Springwell Solar Farm

Written Summary of Oral Submissions
at Issue Specific Hearings 2, 3 and 4

EN010149/APP/8.22
Revision 1
Deadline 3
August 2025
Springwell Energyfarm Ltd

DOCUMENT:  
ENVIRONMENTAL STATEMENT  
VOLUME 2: FIGURES  
REGULATION 5(2)(a) & 5(2)(l)(ii)

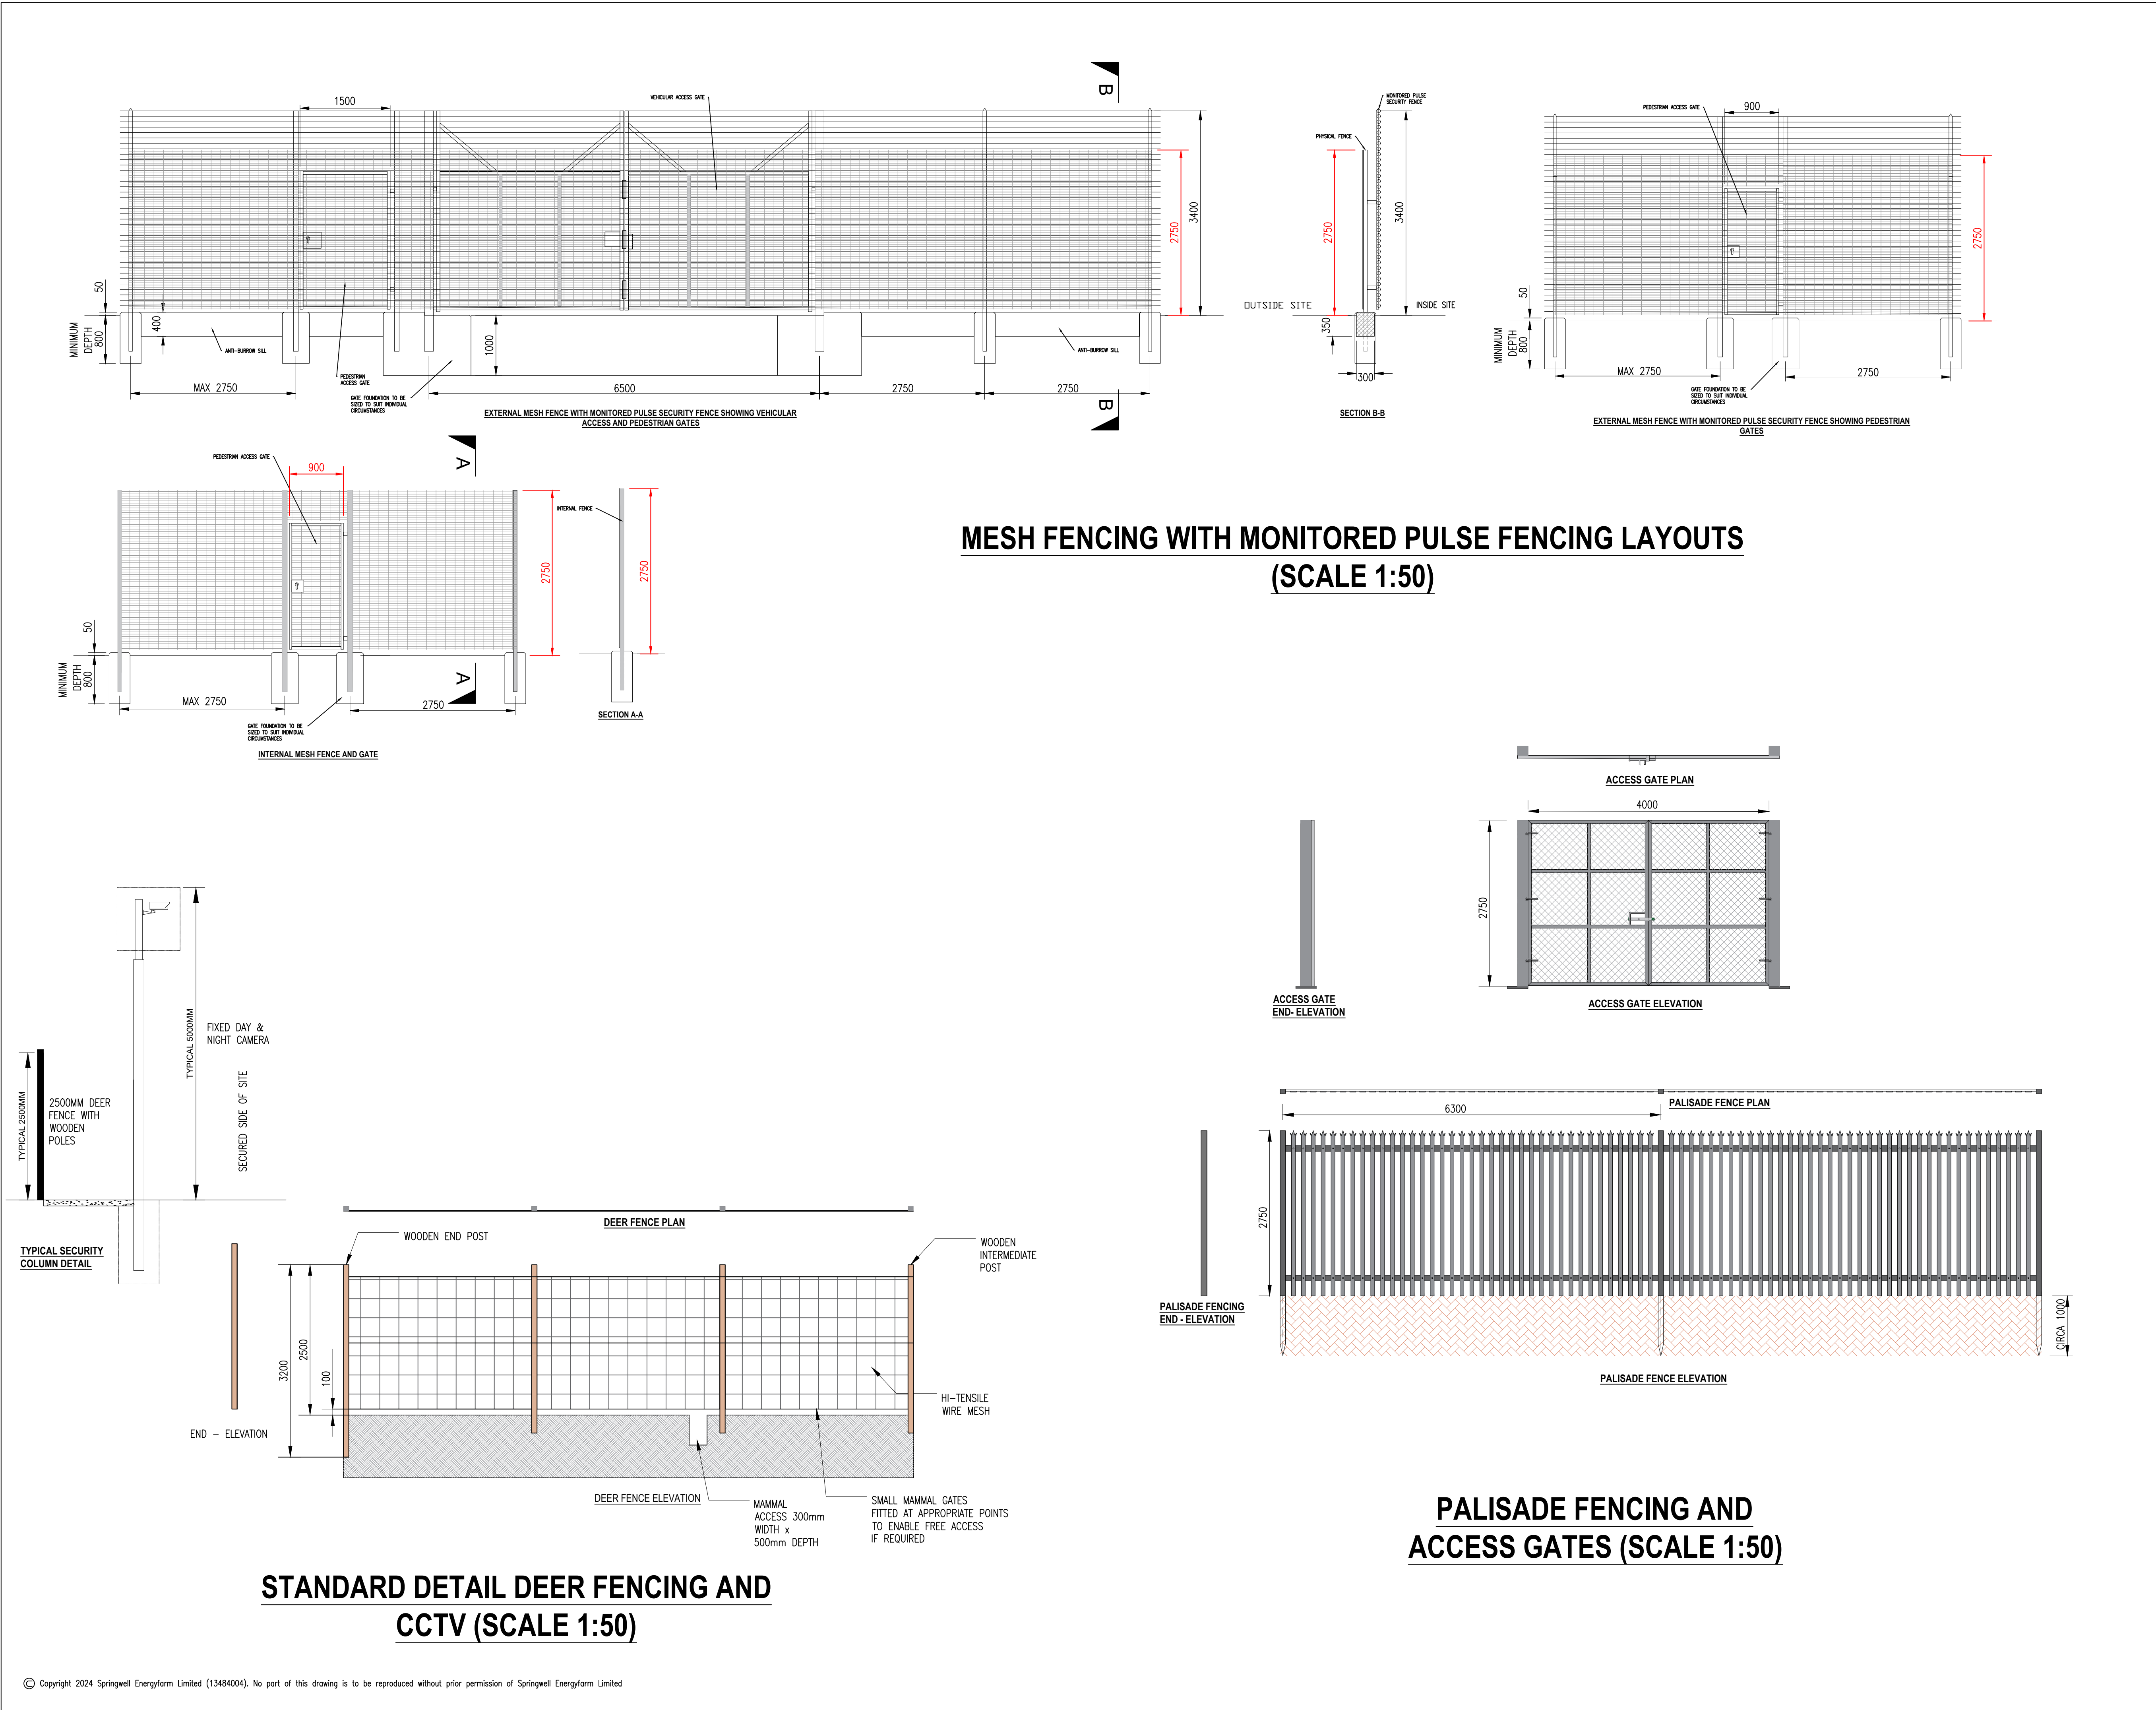
#	Agenda item	Written summary of Applicant's oral submissions at ISH 2
	3.3 The Applicant will be asked questions relating to the vegetation removal parameters (Figures 3.11A to 3.11F) [EN010149/APP/6.2.2] [REP1-027] and how landscape and visual impacts will be accounted for in finalising the location of vegetation removal.	<p>The ExA asked the Applicant if the vegetation removal parameters that are included in Schedule 13 of the Draft DCO [EN010149/APP/3.1.2] [REP1-006] are outline parameters that will inform detailed parameters. Mr Griffiths explained that the Applicant has applied a reasonable worst case approach in accordance with the Rochdale Envelope including the potential removal for these works.</p> <p>Mr Van der Nelson explained that the vegetation removal locations have been guided by the Project Principles and have included consideration of LVIA impacts as part of the pre-application design process. The vegetation removal parameters presented in the Outline Landscape and Ecological Management Plan (oLEMP) [EN10149/APP/7.9.2] [REP1-064] takes account of highways construction works, internal access tracks, cable routes and the grid connection corridor. He continued and explained that should the DCO be granted consent, detailed LEMP(s) will be produced for the Proposed Development in accordance with the DCO Requirement in Schedule 2 of the Draft DCO [EN010149/APP/3.1.2]. He added that the LEMP(s), as it could be one or more LEMPs, would require approval by the relevant planning authority prior to commencement of construction and would be required to be substantially in accordance with the framework set out in the oLEMP [EN10149/APP/7.9.2], including the Vegetation Removal Parameters presented in Appendix 2. Mr Van der Nelson explained that the Applicant has designed for a reasonable worst case and the design process means effects should get better. He continued that where future design choices need to be made, these will be guided by the oLEMP [EN10149/APP/7.9.2] [REP1-064], particularly the management objectives in section 4, such as the retention of existing vegetation wherever reasonably practicable (MO1), consideration of local landscape character (MO2) and protecting the amenity of PROW (MO9). The Design Commitments [EN010149/APP/7.4] [APP-0138] provide further controls regarding vegetation removal, for example, 'Internal access tracks and cable routes will use existing access tracks, crossings and/or gaps in the hedgerows where practicable' (D1) that the Applicant will need to demonstrate compliance with when the detailed design is submitted to the relevant planning authority under Requirement 5 of the Draft DCO [EN010149/APP/3.1.2] [REP1-006].</p>

#	Agenda item	Written summary of Applicant's oral submissions at ISH 2
		<p>The ExA asked the Applicant if the vegetation removal areas are to be in different areas to the vegetation removal plan or if will it be within refined areas of the parameter areas, and how will LVIA impacts be taken into account in finalising the vegetation removal. Mr Griffiths on behalf of the Applicant explained that there will be refinement in the vegetation removal plan as the Applicant has made a reasonable worst case assessment. As is established in case law, there is no obligation on a developer to assess every permutation that could arise on any scheme. In any event, Schedule 16 of the Draft DCO [EN010149/APP/3.1.2] [REP1-006] provides a safeguard because when approving the LEMP the Applicant will need to provide the relevant planning authority with a statement setting out if there are any new environmental effects, which the relevant planning authority will consider and confirm if they agree. If there is a difference that the Applicant could not predict e.g. because the baseline has changed, the Applicant would include that in its statement and the relevant planning authority can assess the difference through that mechanism and determine whether to approve the discharge of the requirement.</p> <p><i>Visual Impact and Design</i></p> <p>3.4 The Applicant will be asked about the design process that is secured in the draft Development Consent Order and control documents.</p> <p>The ExA asked the Applicant if there has been a design process to date that shows that the colour commitments in design commitment D17 are appropriate, such as a landscape colour study or a study of local buildings that have informed the issues. Mr Van der Nelson stated that the Applicant will come back in writing on this point, but in accordance with the requirement 5 in the Draft DCO [EN010149/APP/3.1.2] [REP1-006] the Applicant must have detailed design approved by the relevant planning authority.</p> <p>The ExA noted that Requirement 5 lists in accordance with the Design Commitments [EN010149/APP/7.4] [APP-0138], but wanted further information on how the colours in the Design Commitments [EN010149/APP/7.4] [APP-0138] had been identified. Mr Griffiths explained design commitment D17 states that the colours must be sensitive to the local environment, so when the Applicant submits the detailed design to the relevant planning authority that is the security mechanism. He also noted that the Applicant considers</p>

#	Agenda item	Written summary of Applicant's oral submissions at ISH 2
		<p>these colours appropriate and that consultation with the relevant planning authorities has been carried out, including on the project's design-led approach as set out in the oLEMP [EN010149/APP/7.3.2] [REP1-056]. He added that the colours are also not restricted to grey or dark green but could include other finishes to suit local building styles. Mr Van der Nelson explained the LVIA has fed into this design process too. The ExA clarified that the principle of the query about colour choice in the Design Commitments [EN010149/APP/7.4] [APP-0138] applies to all of the larger components of the Proposed Development, including Work Numbers 2, 3 and 4.</p> <p>Mr Samuel Sheikh, Counsel for North Kesteven District Council (NKDC) raised a concern about the flexibility at the discharge of requirements stage, as the Design Commitments [EN010149/APP/7.4] [APP-0138] specifies specific colours. NKDC will put their views in writing. The ExA asked the Applicant if any consultation had been held on these colours. Mr Griffiths confirmed there had been consultation on the Project Principles (which are the design principles considered as part of the DAD). The Applicant will respond in writing if it considers it appropriate to provide any more flexibility to amend the design principles.</p> <p>Post hearing note: The Applicant has provided a written response to address the points raised in this section in Action Point 2 and Action Point 3 of the Response to Action Points, which is appended to this document.</p> <p>3.5 North Kesteven District Council will be asked to expand on its concerns relating to the visual impact of highways components.</p> <p>Mr Oliver Brown for NKDC confirmed that the Applicant has clarified what was included in the vegetation works. There has been a meeting with the Applicant and they have clarified how the process will work – including the vegetation removal plans within the oLEMP [EN010149/APP/7.9.2] [REP1-064] and how it is secured within the Draft DCO [EN010149/APP/3.1.2] [REP1-006]. He added that NKDC is happy in terms of the information that has been presented in the vegetation removal plans and the information presented in the LVIA.</p>
